WATERLOO METRO QUARTER BUILDING 2

**SSD-10439 - RESPONSE TO SUBMISSIONS
SUPPLEMENTARY DESIGN REPORT**

This report contains the Responses to the City of Sydney comments (dated 3rd December 2020), DPIE comments (dated 14th December 2020) and EES comments (dated 26th November 2020) relating to the architecture and design. It is intended to be read in conjunction with the updated Architectural Drawings submitted as part of the Response to Submission.

**Image 1c: Building 2 Proposed Floor Plan**

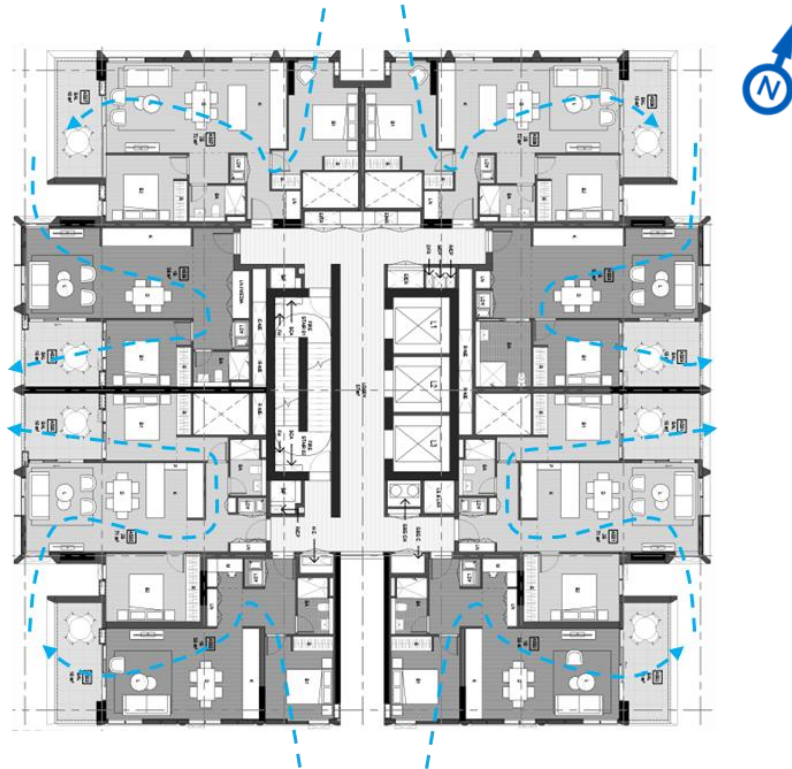
- Built Form**
- **Tracker Item 2.21** – The Panel accepts that the central apartment building layout can satisfy the minimum requirement for natural cross ventilation in the Apartment Design Guide. The Panel requests a diagram showing openable window locations in all apartments to clarify how this ventilation will be achieved, whilst maintaining visual and acoustic privacy between units.
